From: Carmichael Ian <Ian.Carmichael@thamesvalley.pnn.police.uk>
Sent: Friday, November 1, 2019 10:25 AM
To: Caroline Ford <Caroline.Ford@Cherwell-DC.gov.uk>
Cc: Planning <Planning@Cherwell-DC.gov.uk>
Subject: Planning ref: 19/01036/HYBRID (AMENDMENTS). Bicester Eco Town Exemplar Site Phase 2 Charlotte Avenue Bicester.

Planning ref: 19/01036/HYBRID (AMENDMENTS). Bicester Eco Town Exemplar Site Phase 2 Charlotte Avenue Bicester.

Planning ref: 19/01036/HYBRID. Bicester Eco Town Exemplar Site Phase 2 Charlotte Avenue Bicester.

1 West Elevation - River Corridor
1 : 200

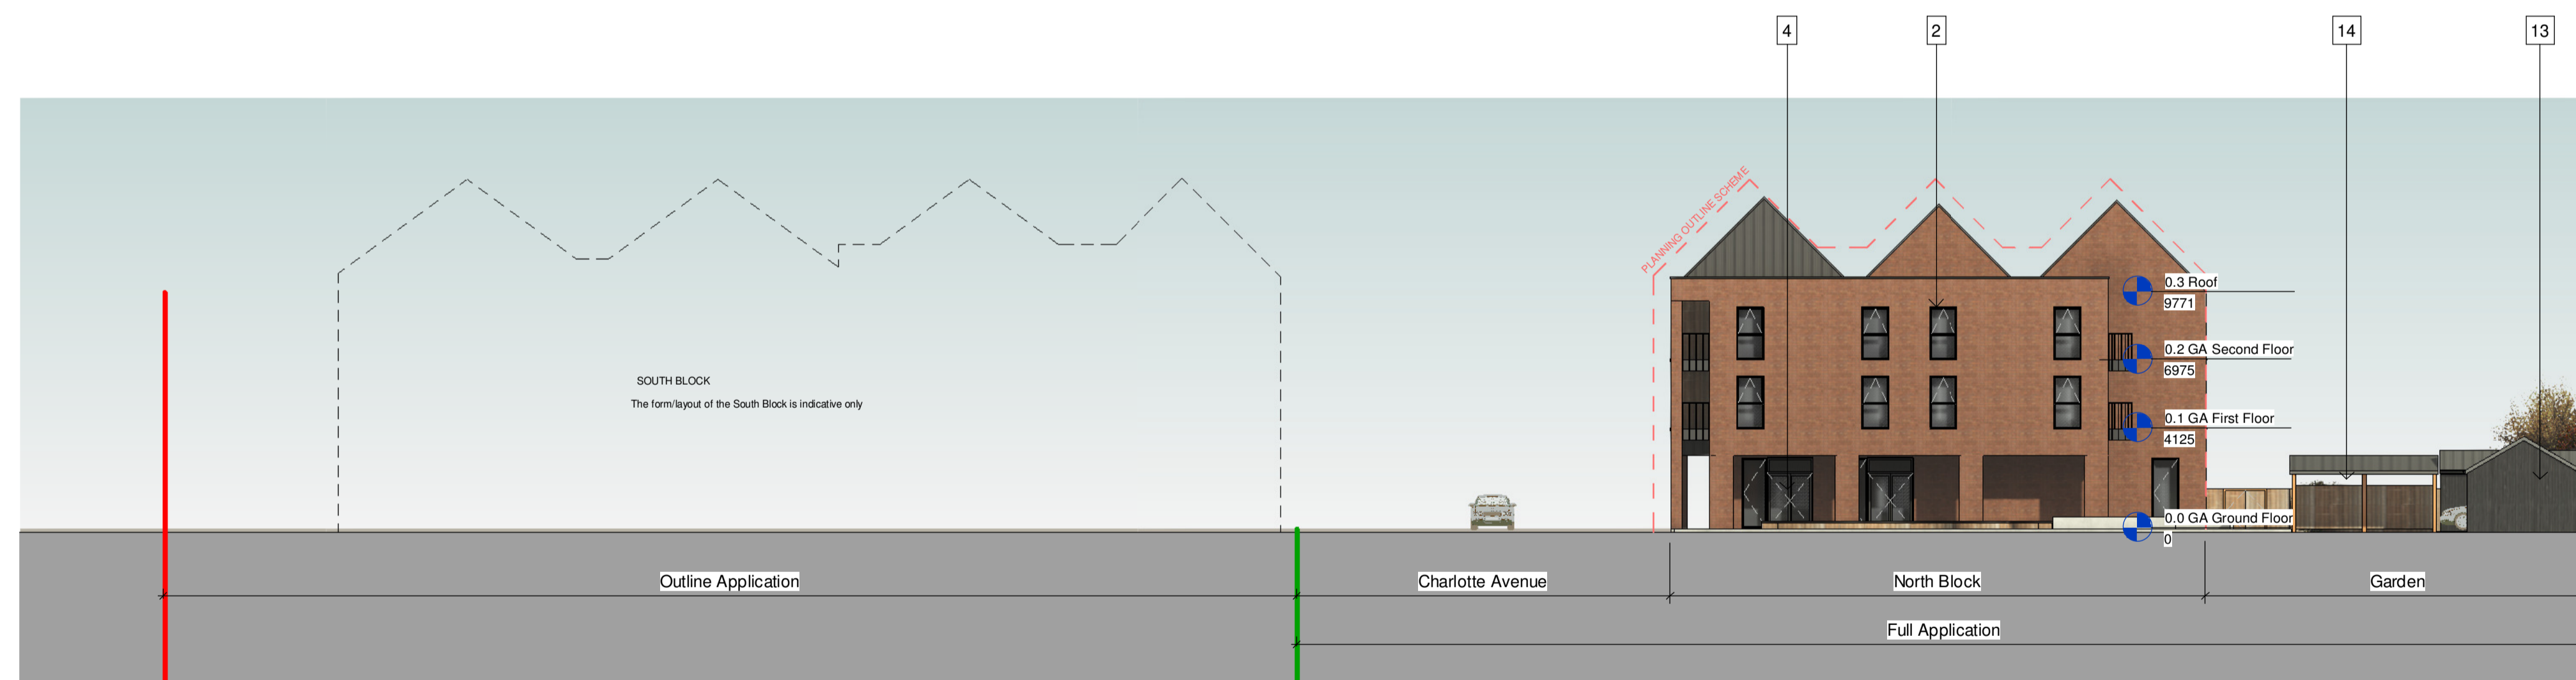
- There are sections of colonnades on some elevations of both blocks. These must be lit independently from above as relying on street lighting to illuminate the undercrofts could create dark hiding places that assist criminal and/or anti-social behaviour.

- Rainwater goods downpipes could be used as climbing aids to reach resident's balconies. They should be incorporated into the fabric of the building or designed so that they cannot assist climbing.

1 North Elevation - Rear Elevation
1 : 200

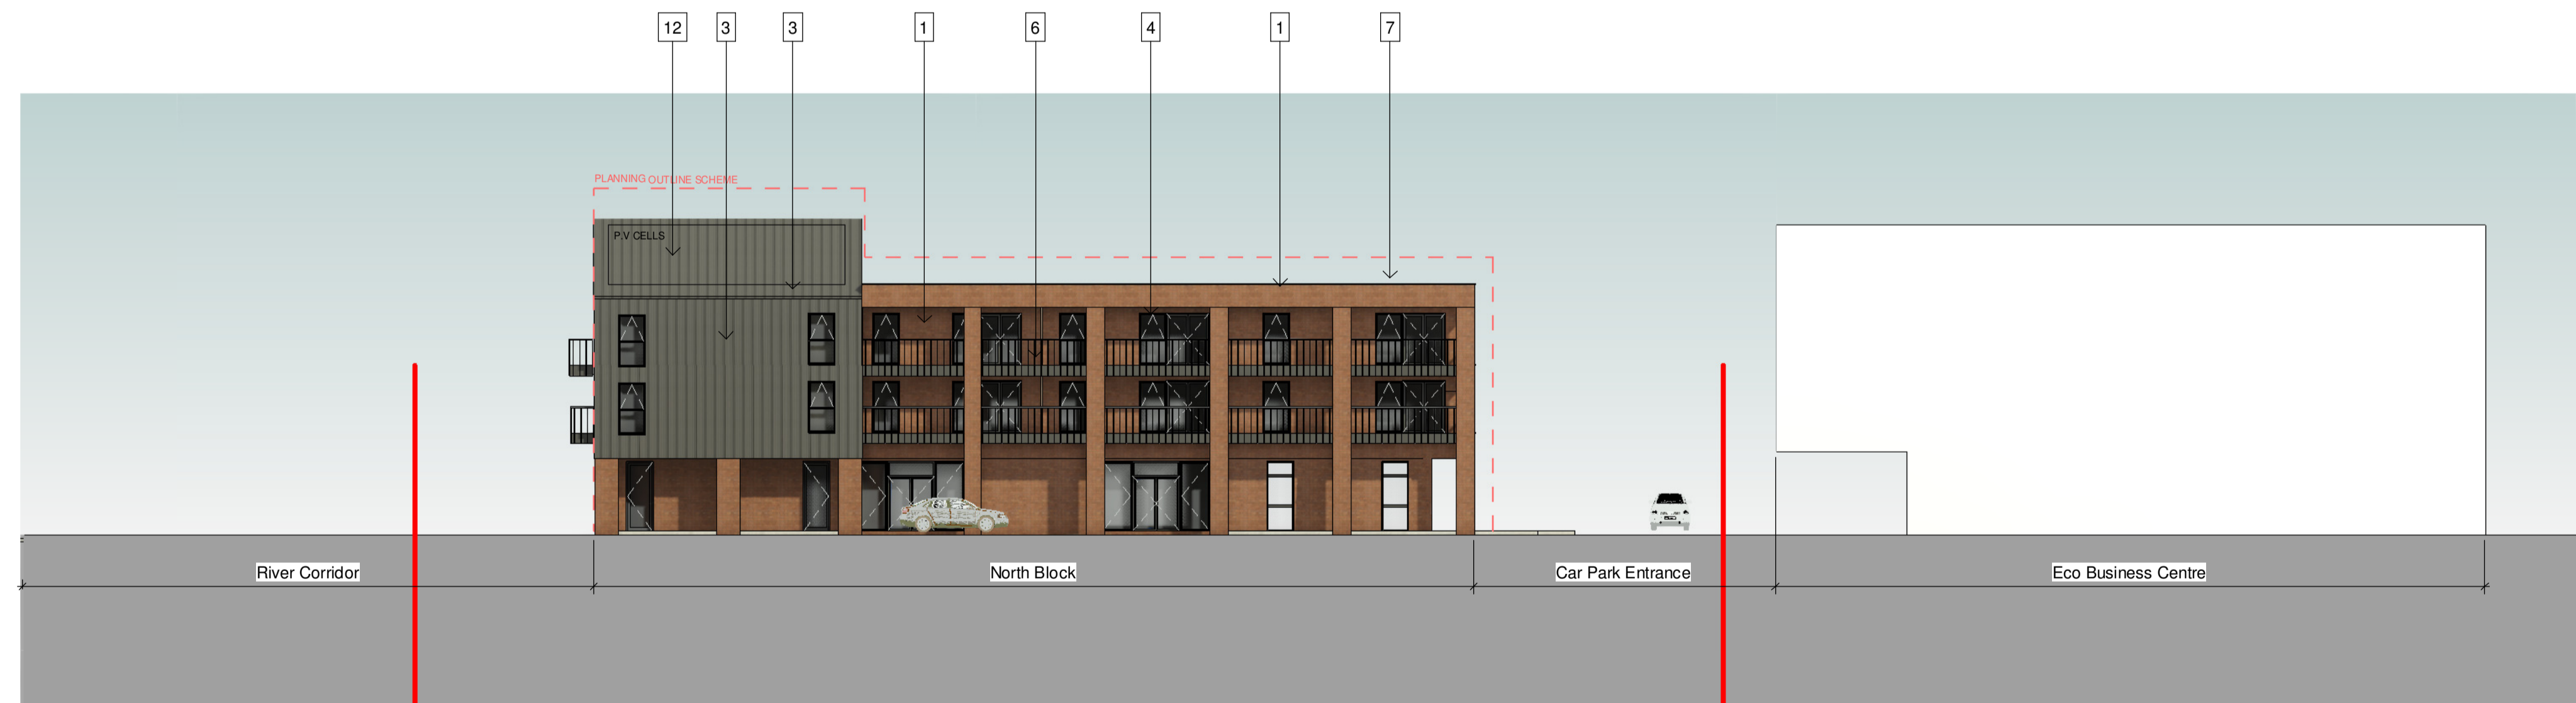
- The glazing/curtain walling of the ground floor units must meet SBD standards and, if security shutters are to be provided during construction or in at any point in future, they should be visually permeable as solid features deaden frontages and increase the fear of crime.
